**From:** George Smith  
**Sent:** 19 November 2019 09:10  
**To:** DC Support  
**Subject:** FW: 19/02075/F

**From:** Roger Shipway [REDACTED]  
**Sent:** 05 November 2019 11:03  
**To:** George Smith <George.Smith@Cherwell-DC.gov.uk>  
**Subject:** 19/02075/F

Please find below further comments on the applicants revised documents

Following a re-issue of documents we have looked further at the Arboricultural Statement and the new site plan and have further concerns to STONGLY OBJECT to the proposals.

Site Plan
AS PROPOSED
Scale 1:200

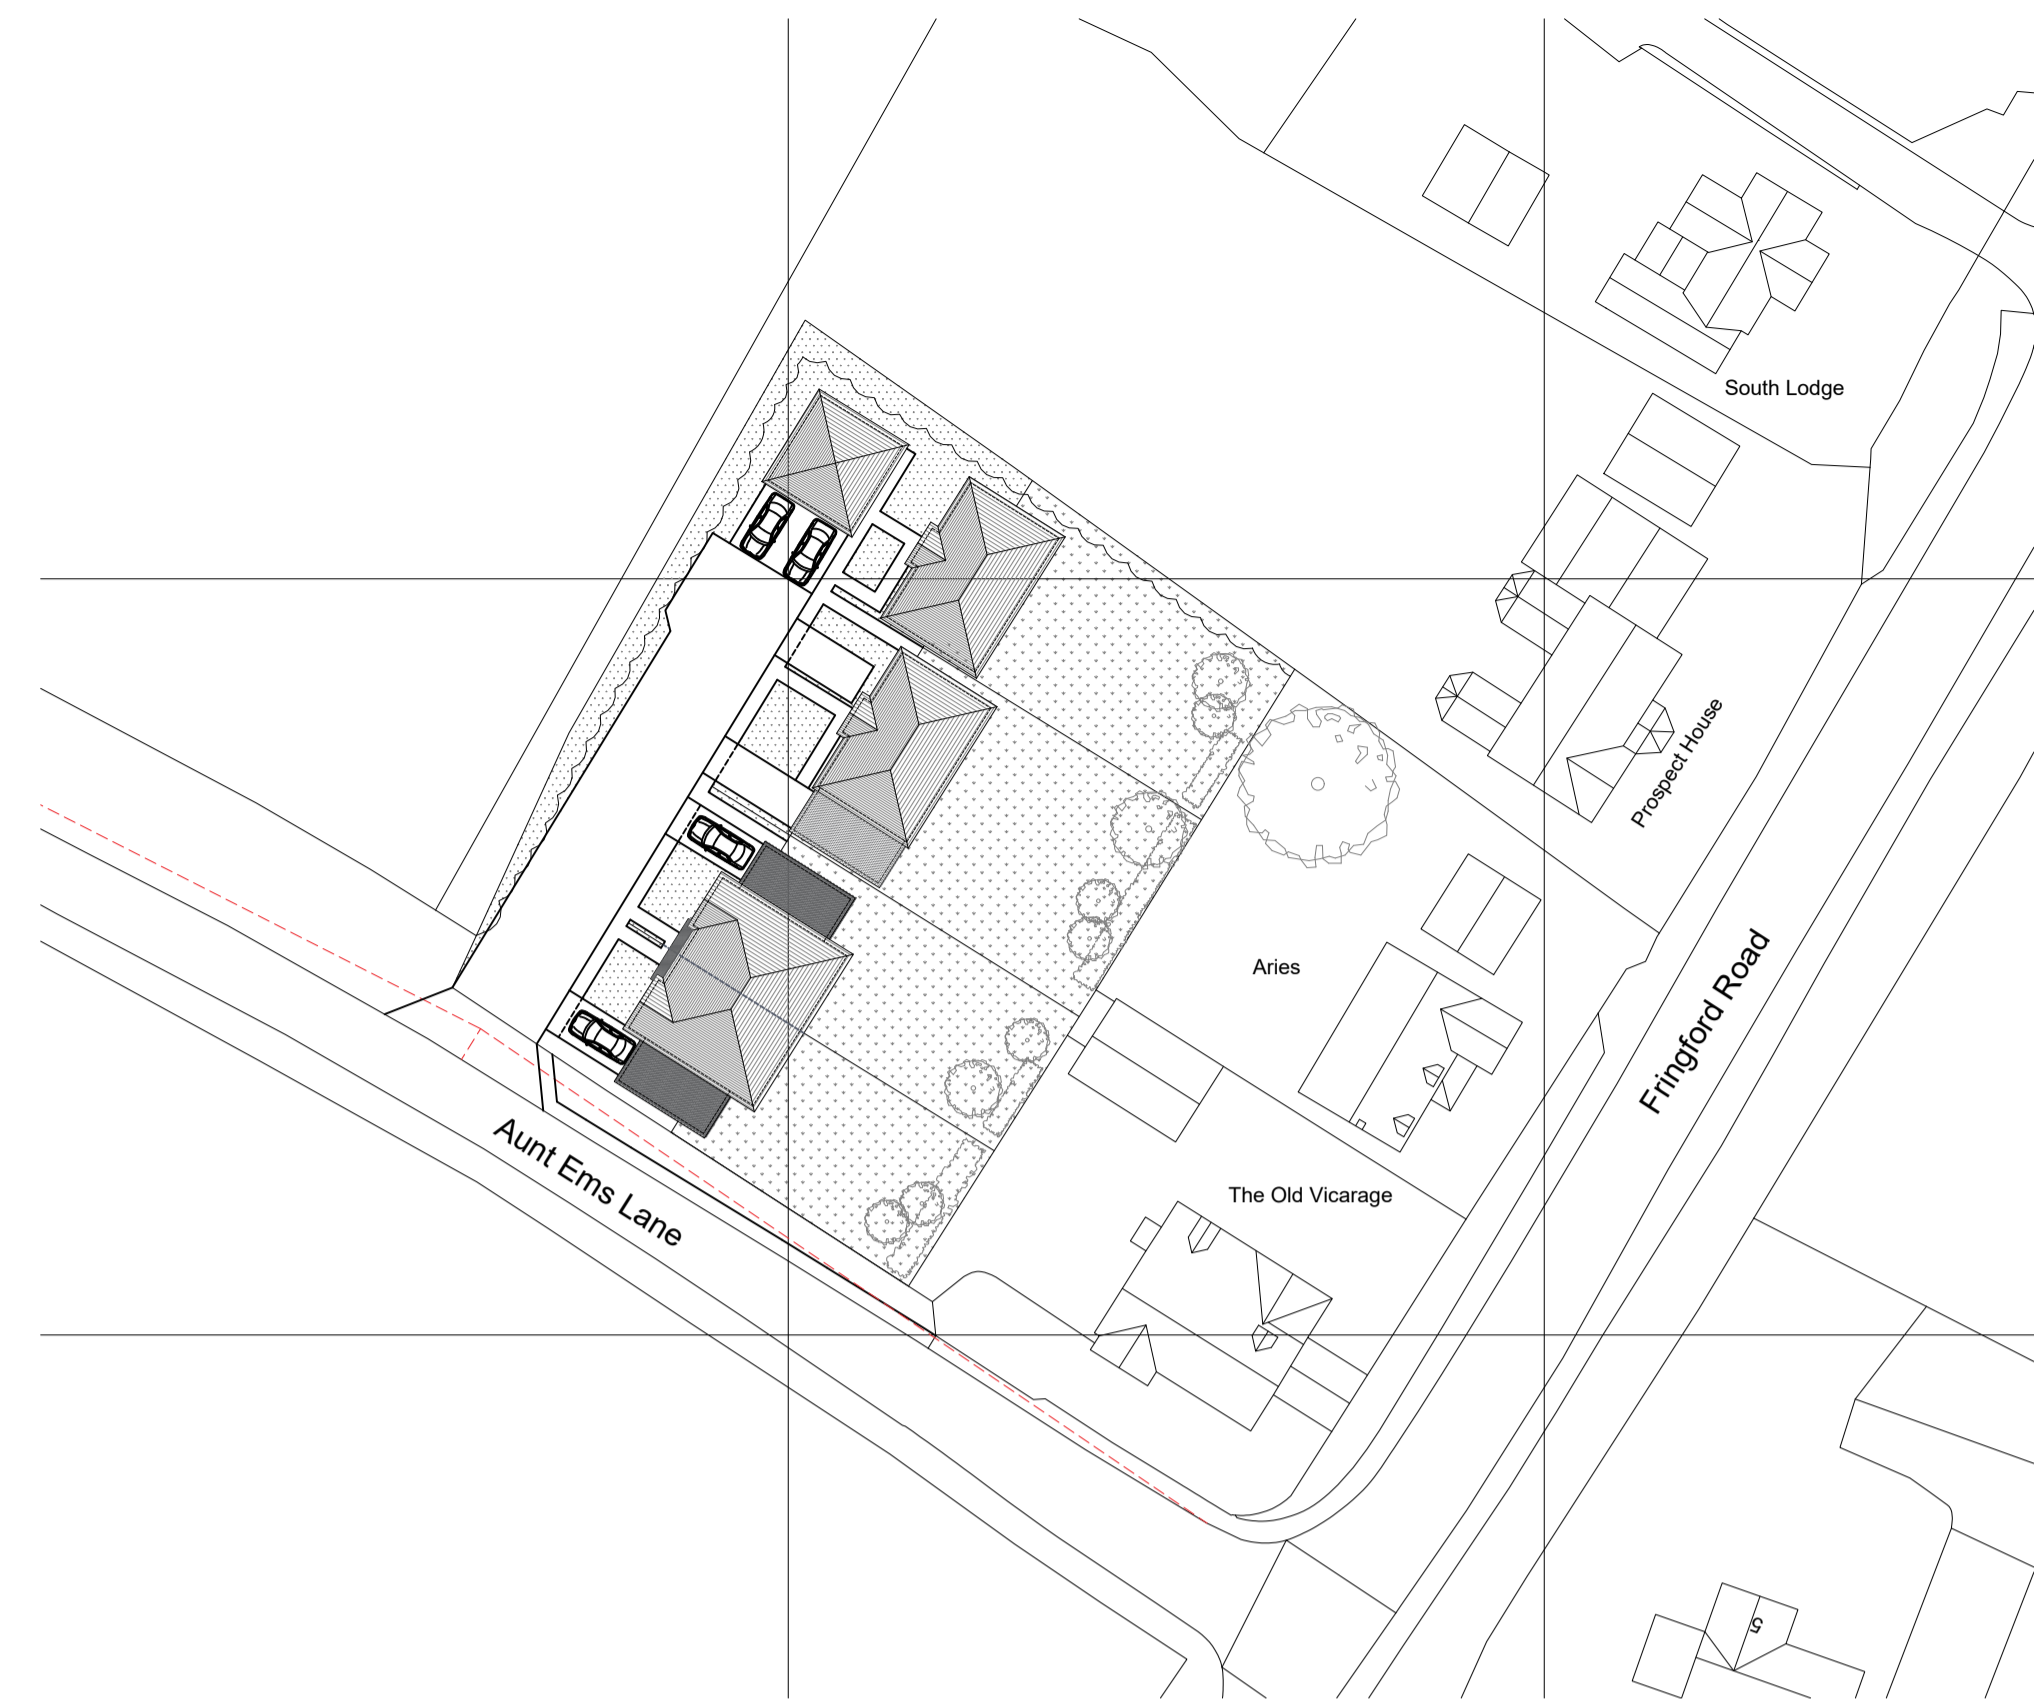
1. Despite moving the end detached house less than a metre to the south and losing the residents access to their back garden, we have concerns that there is still insufficient room between the house and the plot boundary to provide a sufficient tree protection barrier and allow room for scaffolding etc needed to build the end wall.
2. We are also concerned that the tree protection boundary line in the plan in Appendix 1 on the reverse of page 14 of the report appears to have been bent to accommodate the positioning of the house. We understand any Arboricultural Consultant is supposed to be independent, but this makes it look as though he is acting for the applicant.

We also note the new beech hedge to the east of the plots is not continuous, but no reason is given for this. Has this anything to do with the existence of the applicants septic tank in the grounds of the northernmost semi detached house? The hedge may grow to a height of 5 metres therefore it would have adverse effects on our property adding to our objections to the application.
